Office of  
Environment  
& Heritage

Our reference: DOC14/253285  
Contact: Marnie Stewart, 9995 6868

I refer to your letter received by the Office of Environment and Heritage (OEH) on 7 October 2014 inviting comments on the Environmental Impact Statement (EIS) during the public exhibition for the Moorebank Intermodal Terminal at Moorebank Avenue, Moorebank (SSD-5066).

## **Attachment 1: OEH comments on the exhibited Moorebank Intermodal Terminal Facility SSD 5066 and planning proposal**

Figure 8.1 Location of proposed biodiversity offset areas

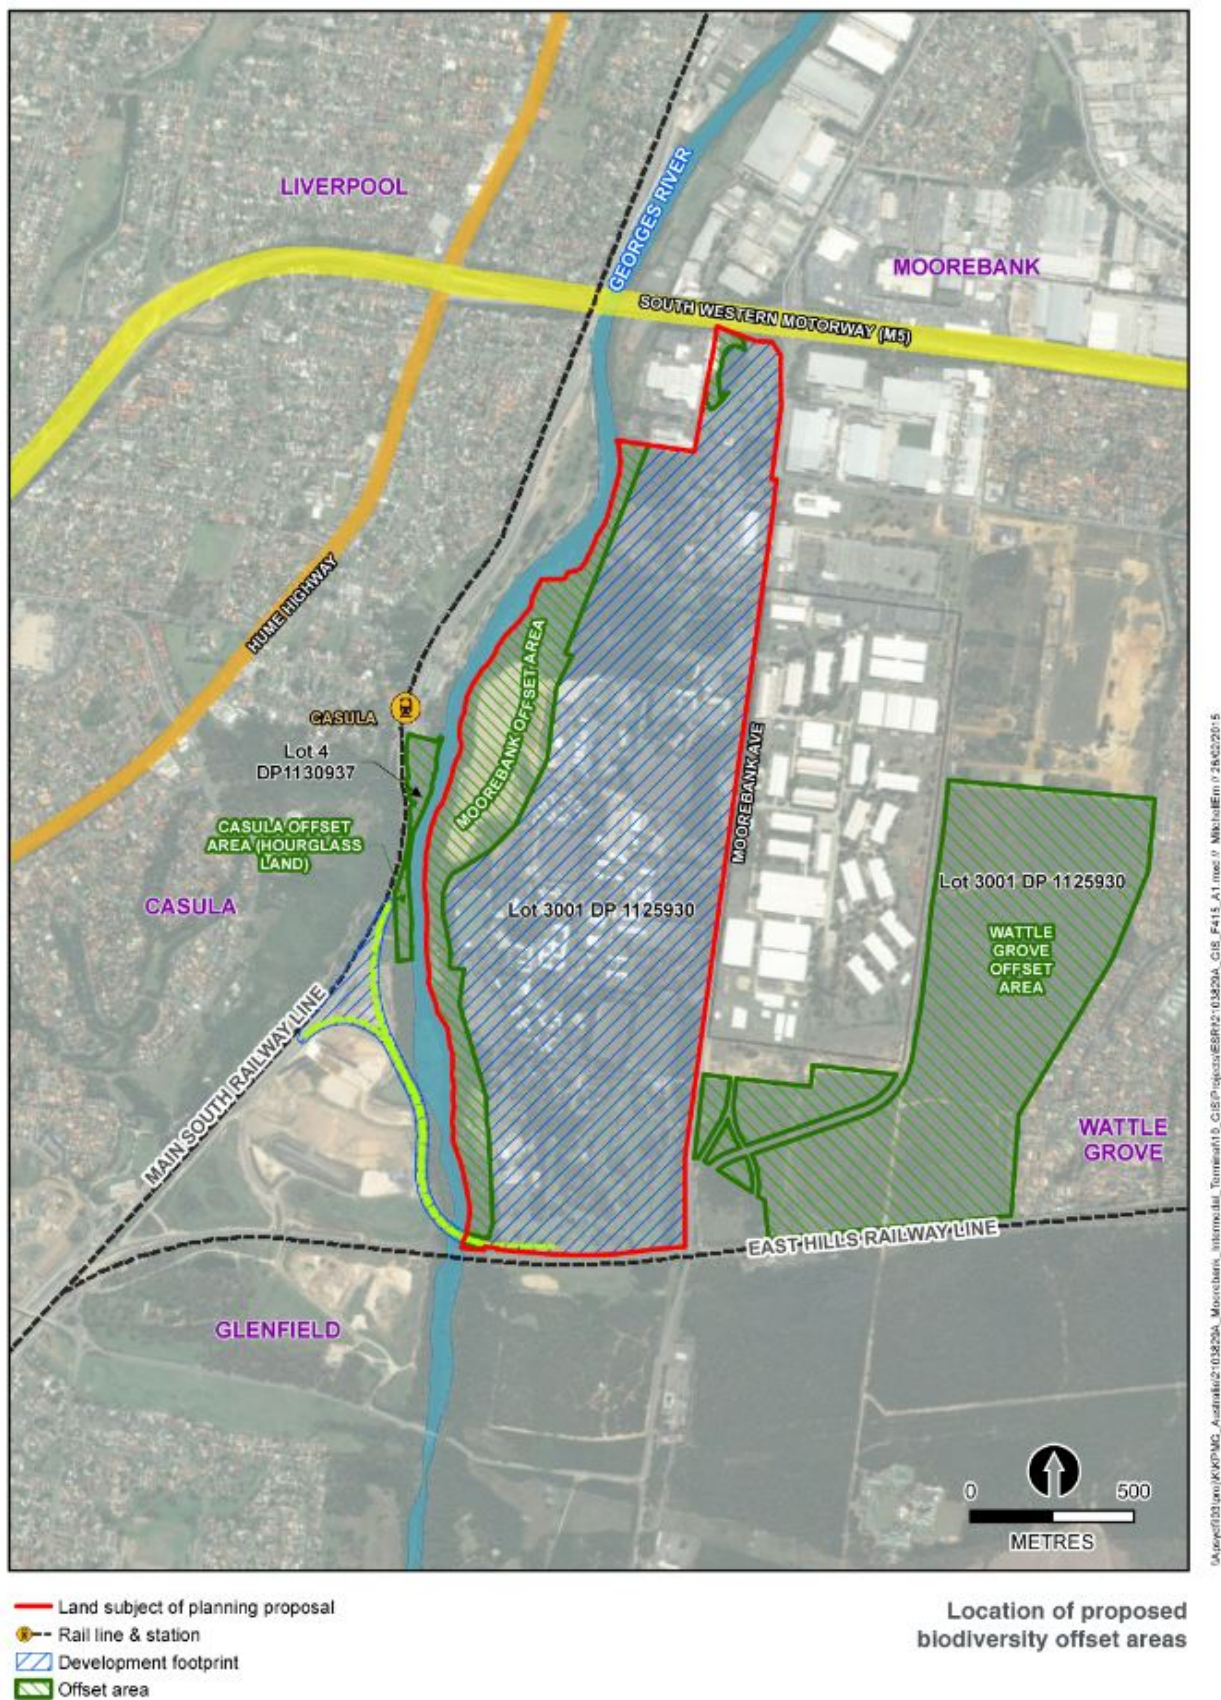
As previously advised in correspondence dated 11 September 2014, in regard to the proposed Moorebank Conservation Area, OEH raises significant concerns that figures 1.3–1.5 in the EIA depict a much smaller 'conservation area' compared to the proposed 'offset area' depicted in figures 6.1-6.3 in the EIA and figures 4.1-4.3 in the Offset Strategy. Figures 1.3-1.5 depicts the 'conservation area' as extending from the Georges River to the 1% AEP flood level. Whereas, in addition to the 1% AEP flood area, the proposed 'offset area' in figures 4.1-4.3 and 6.1-6.3 also include part of the area identified as 'area available for potential development' (as depicted in figures 1.3-1.5). Furthermore, the 'conservation area' in figure 4.4 in the Offsets Strategy appears to be different again (ie even larger in size) than the 'offset area' in figures 6.1-6.3 and 4.1-4.3. It is also noted that the zoning map (figure 23.1) depicts the 'area available for potential development' as IN2 Light Industrial, not an environmental zoning.

OEH does not consider that the area identified as 'area available for potential development' should form part of the proposed 'offset area'. Therefore the relevant offset plans, figures and calculations should be amended to only include the identified 'conservation area' and remove the 'area identified for development'.
